**Objection to Development Application SSD- 93020230 at 40-48 Redan Street, Mosman by Richard Wise Pollitt 69B Muston Street, Mosman**

I refer to State Significant Development Application SSD – 9302 0230 which seeks consent for the demolition of existing dwellings; construction of 10 storey residential flat building comprising: 53 apartments (including 11 in-fill affordable housing apartments), two basement levels with parking for 106 cars, communal open space and associated works at 40-48 Redan Street Mosman.

JOB No.
SY25000244
DRAWING No.
C02.11
REV.
2

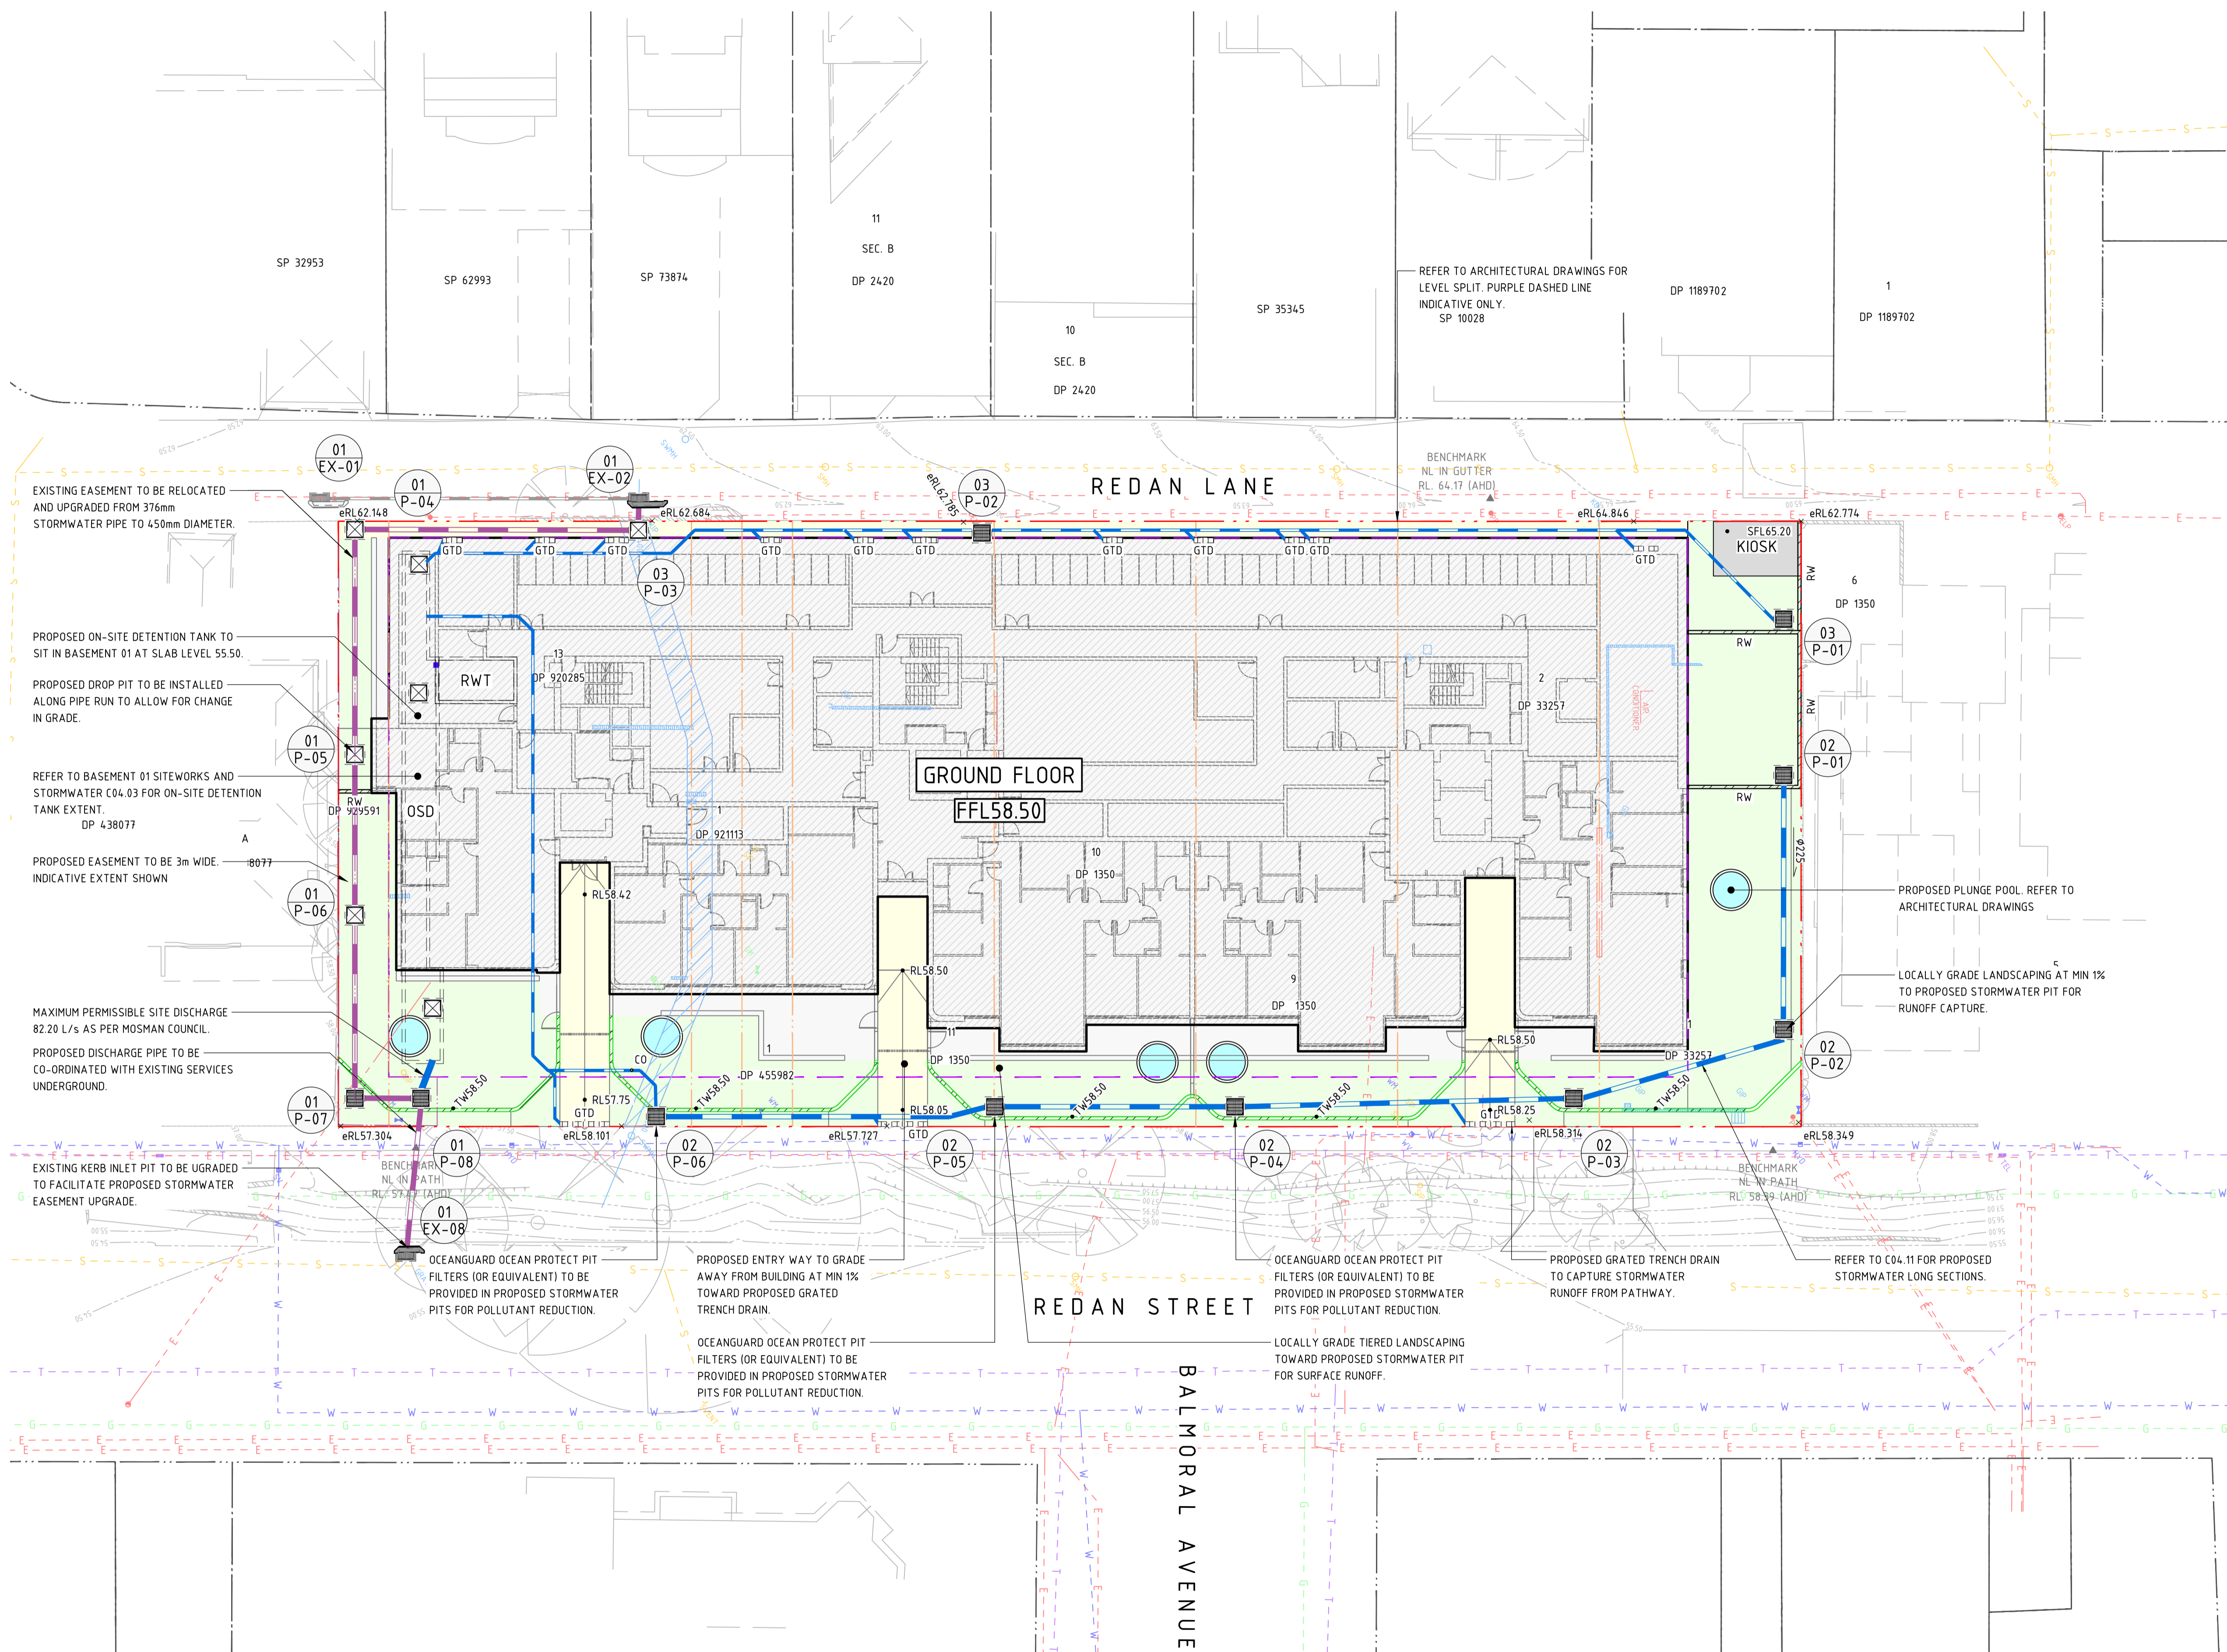
The EIS indicates that construction access will be primarily from Redan Street. However, the civil drawings show a temporary construction ramp in the northwest corner of the site from Redan Lane. Any access from Redan Lane will be problematic due to it’s a very constrained size and access. I request that access should be totally limited to Redan Street.

Site Plan
Site Plan

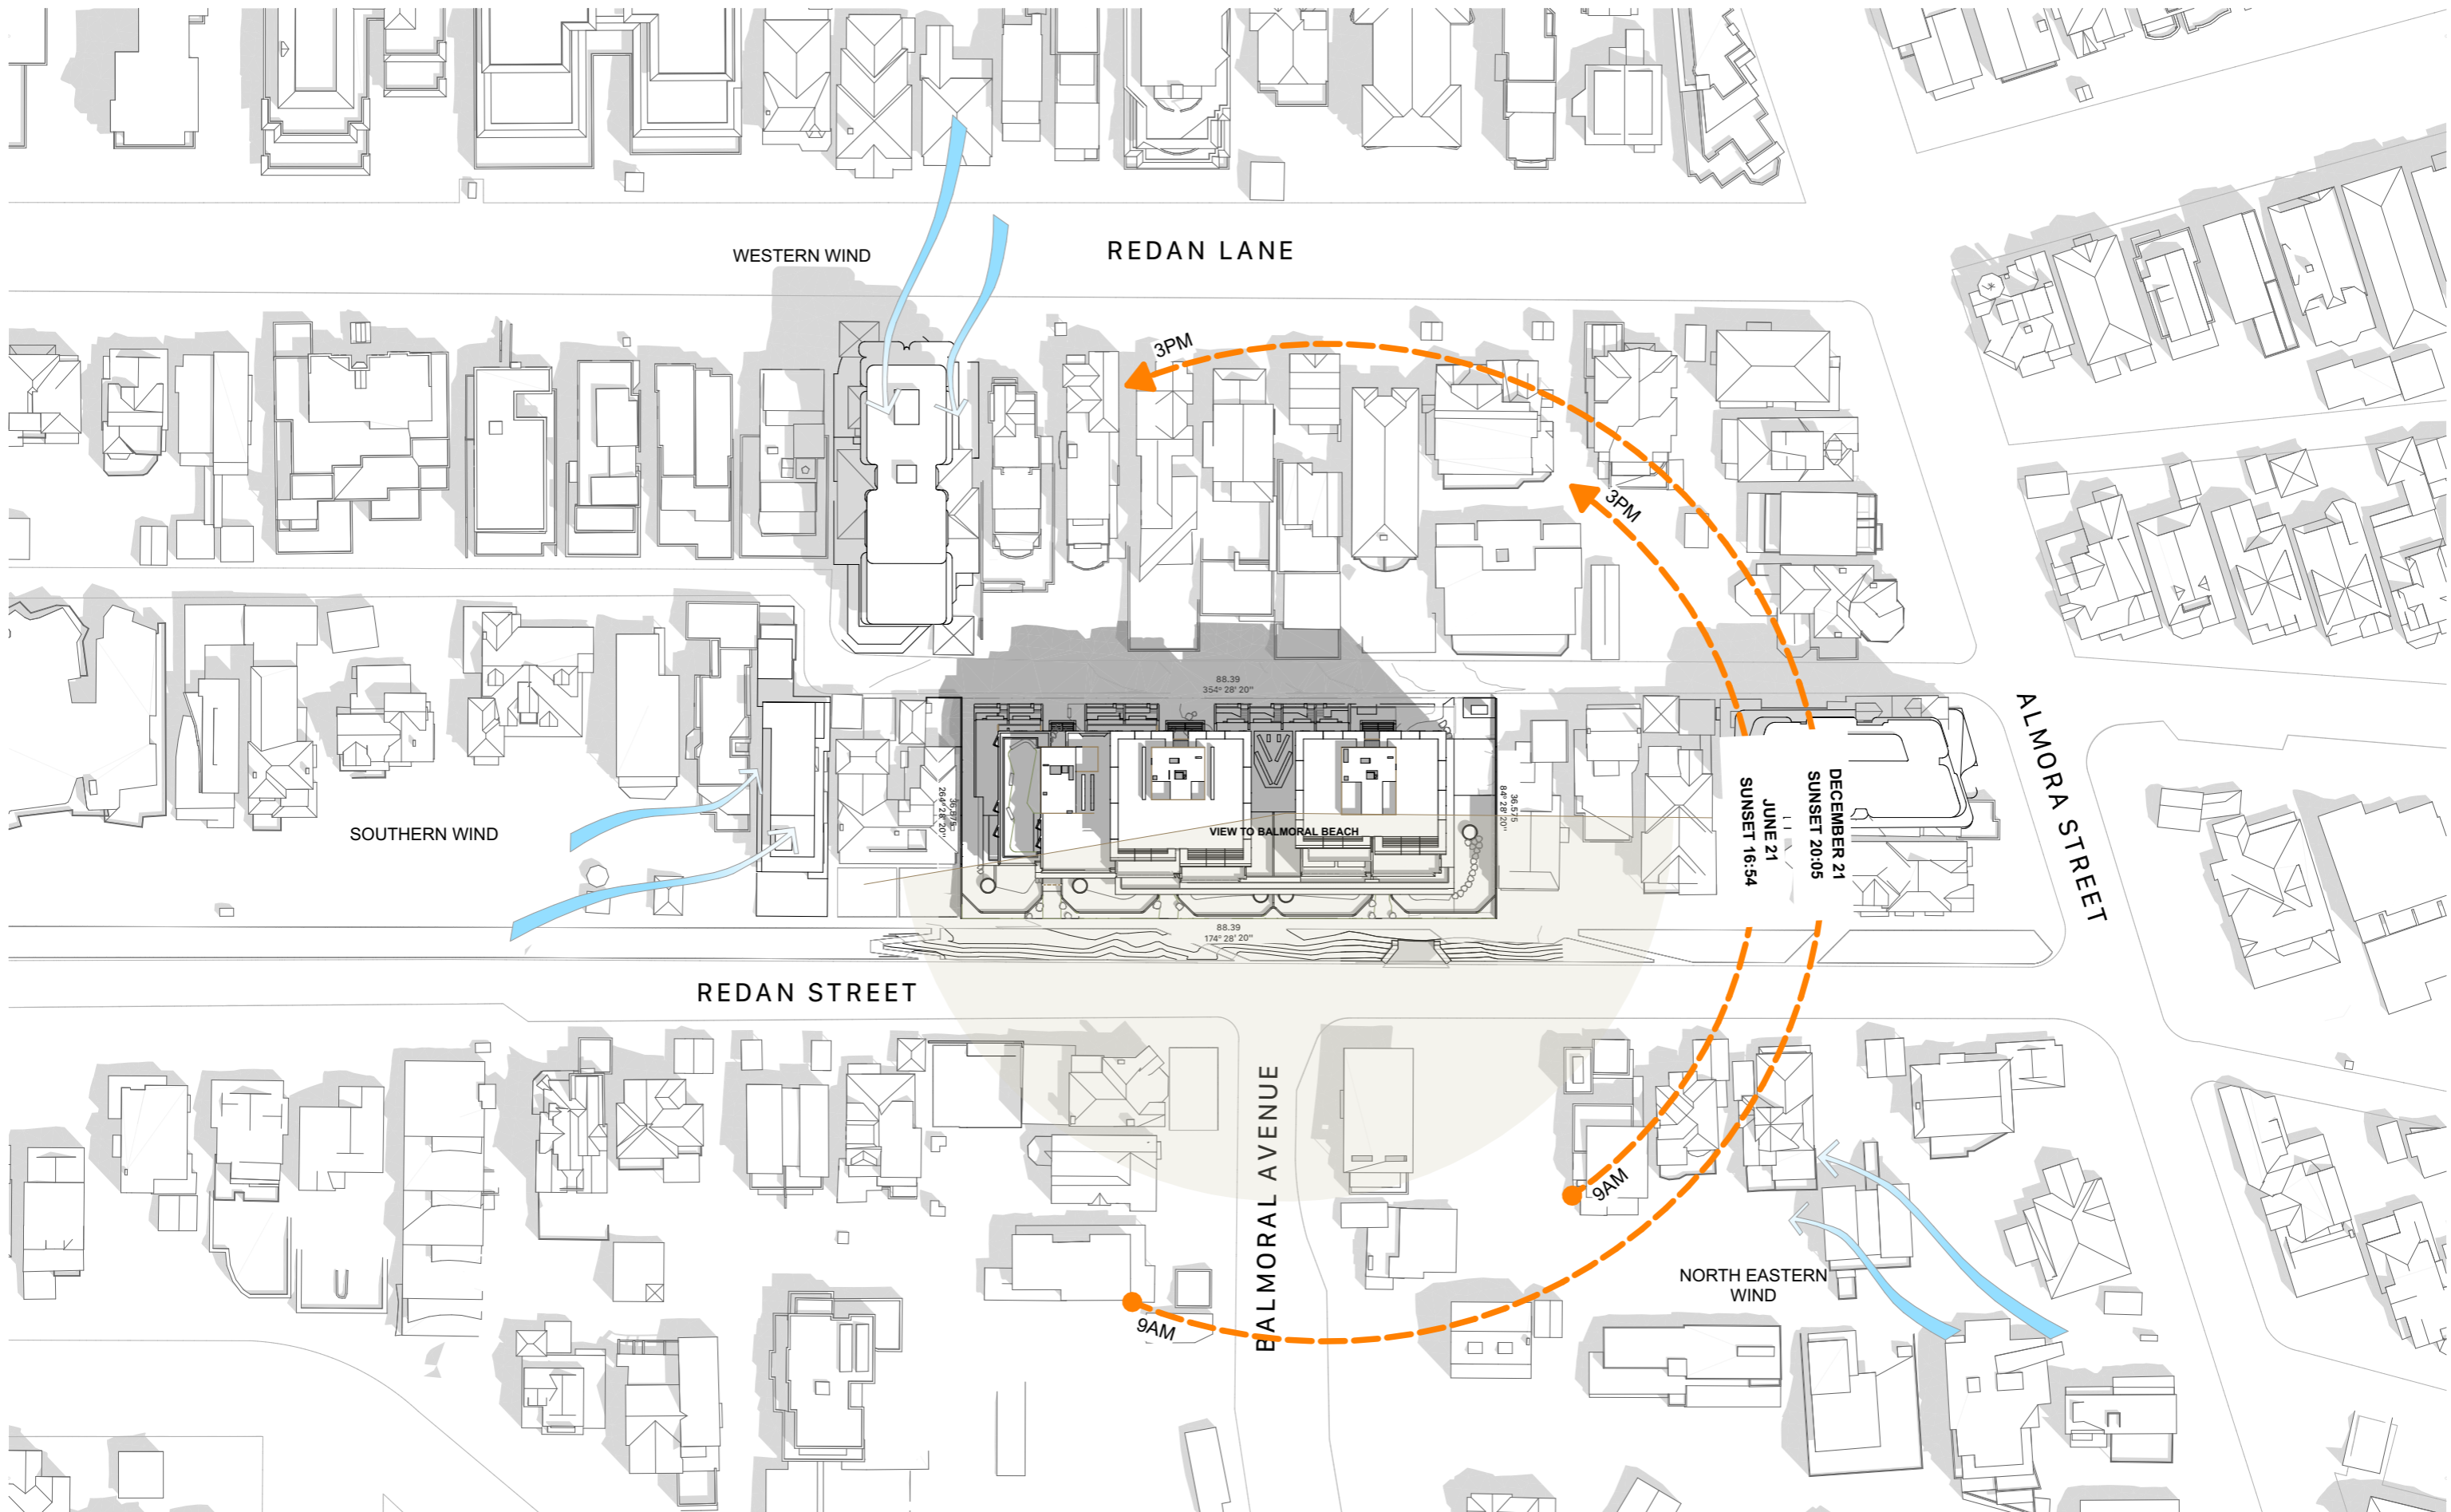
The direction of the summer Seabreeze is shown in fig.7 below. This allows the blocking effect in the wind shadow on our property to be assessed.

Fig. 7 SSD Submission - Site Plan. Marked up to show direction of NE sea breeze and blocking effect on 69 Muston Street

40-48 Redan Street, Mosman 40-48 Redan Street Mosman NSW 2088	Elevation West - Redan Lane Elevations	Rev Date Description By Chk	Scale	Code	Sheet	Rev	0 2.5 5 10m
		B 27/2/2026 SSD Submission Lodgment IS	1:250 @ A3	TPRS	3003	B

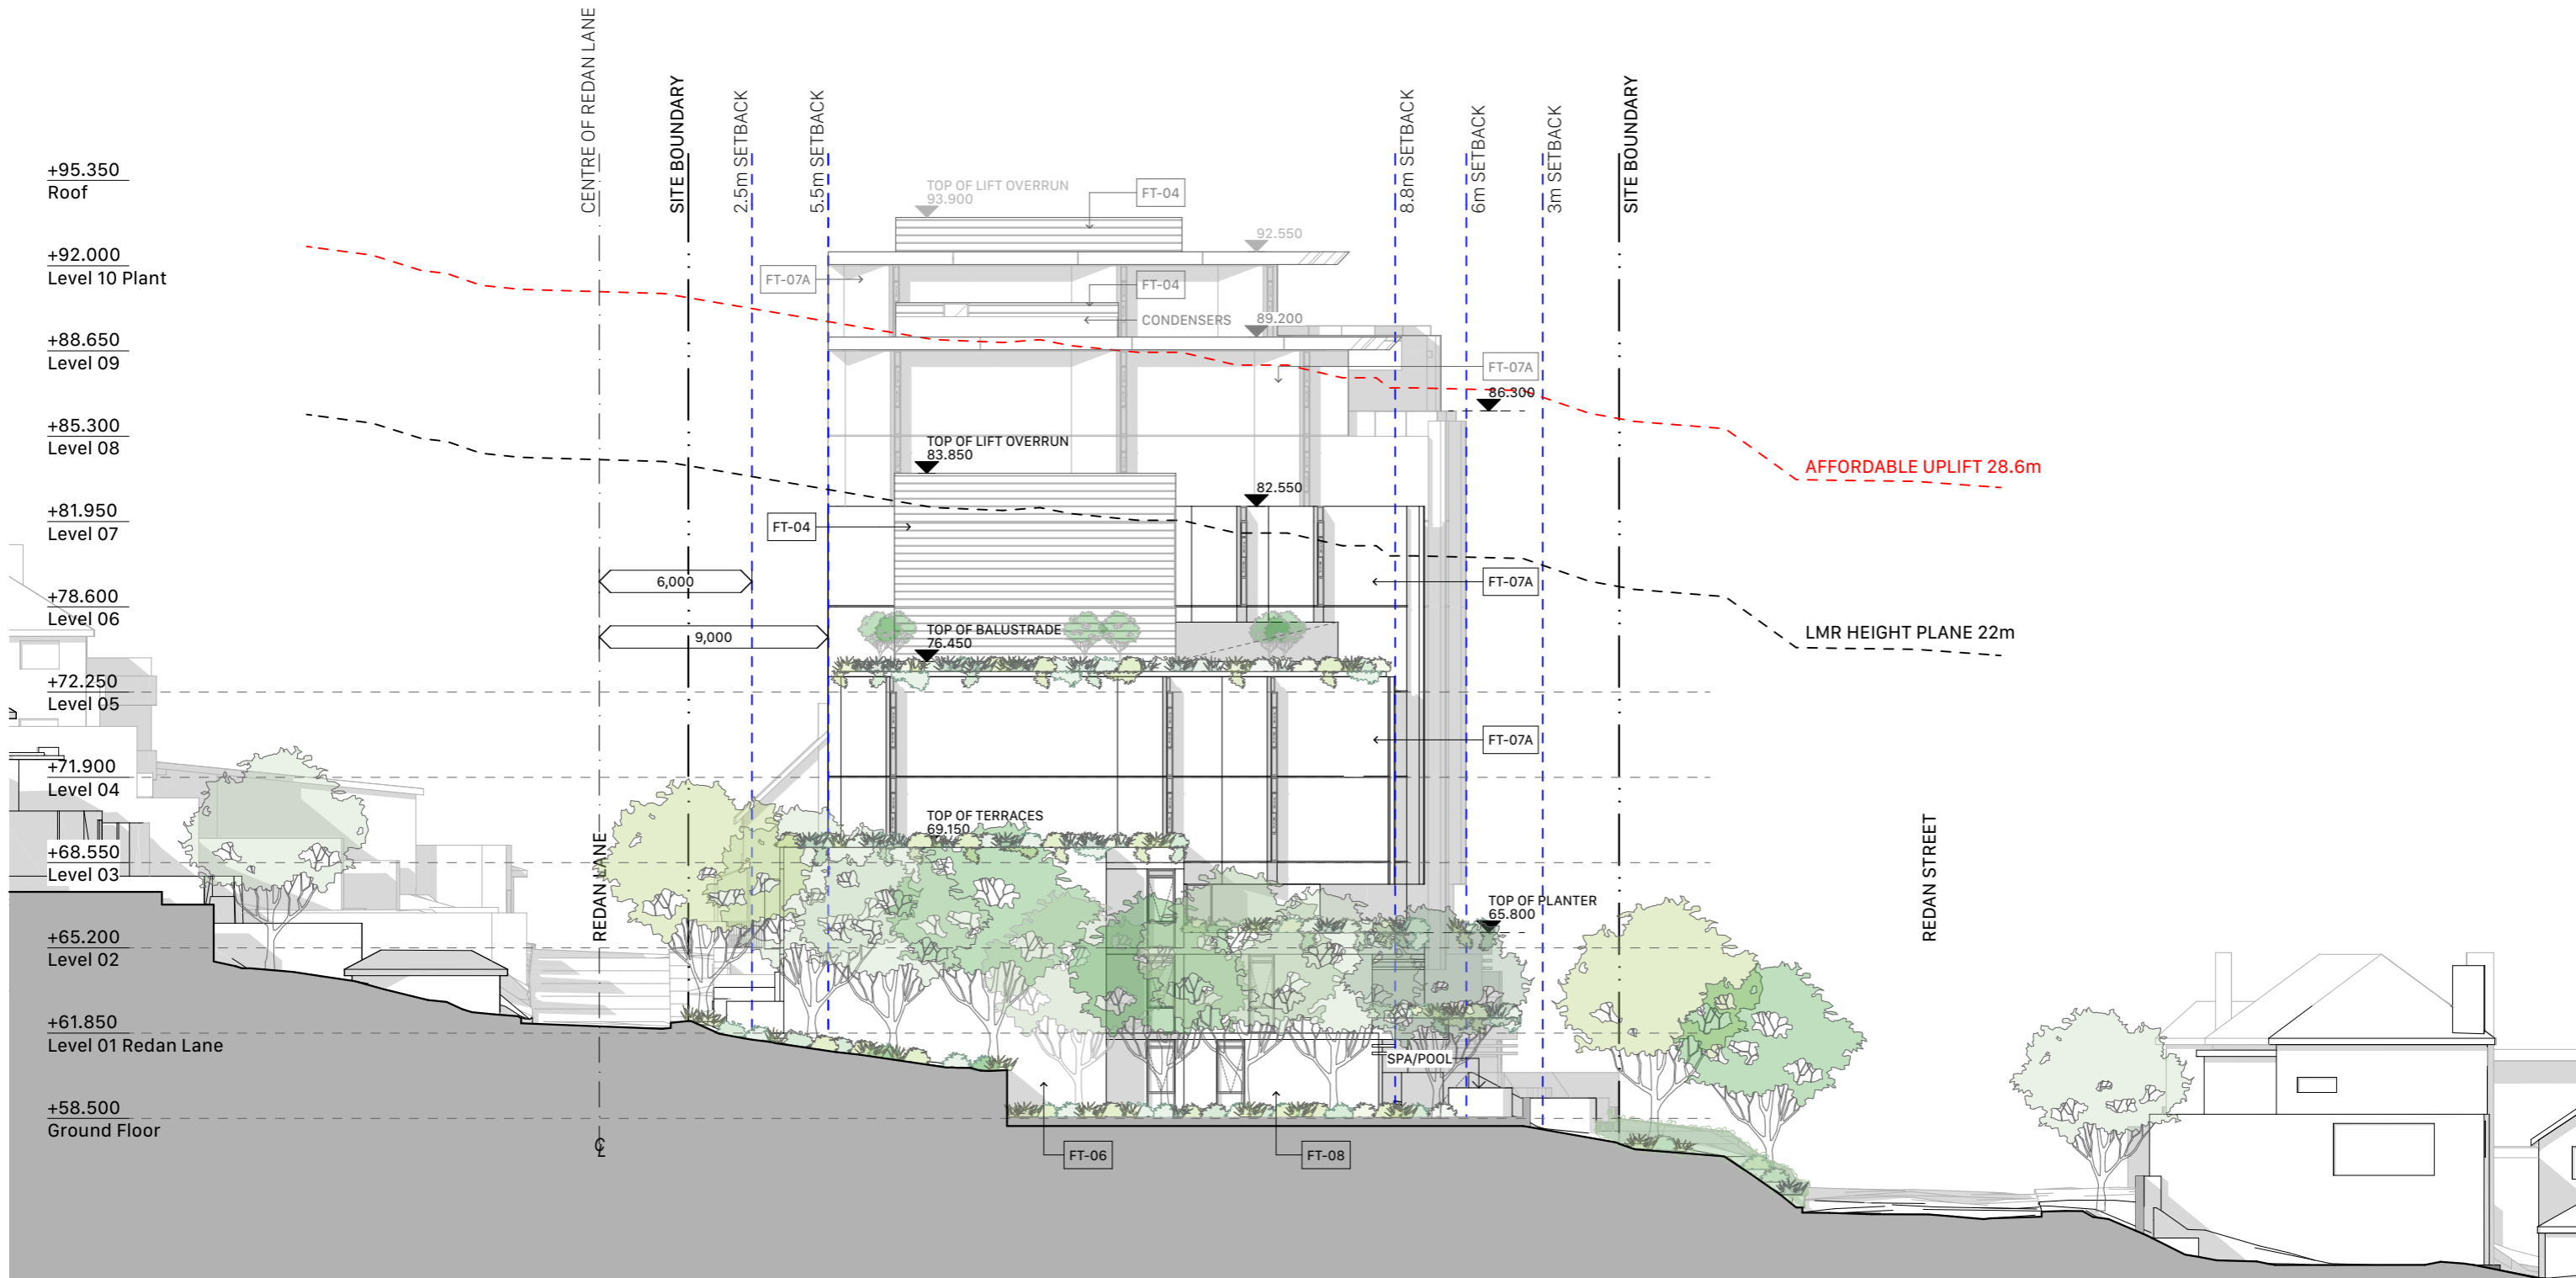
The projection of the profile of our building onto the Western façade of the proposed development is shown in Fig.6 below. It indicates quite clearly that we would totally lose all our harbour and ocean views due to the bulk of the building directly in front of us.

Fig.6 Marked up detail of SSD Submission – Western Elevation Redan Lane - showing relative position of 69 Muston St. looking due East towards the harbour. It clearly indicates that harbour views from 69B Muston St, would be totally blocked.
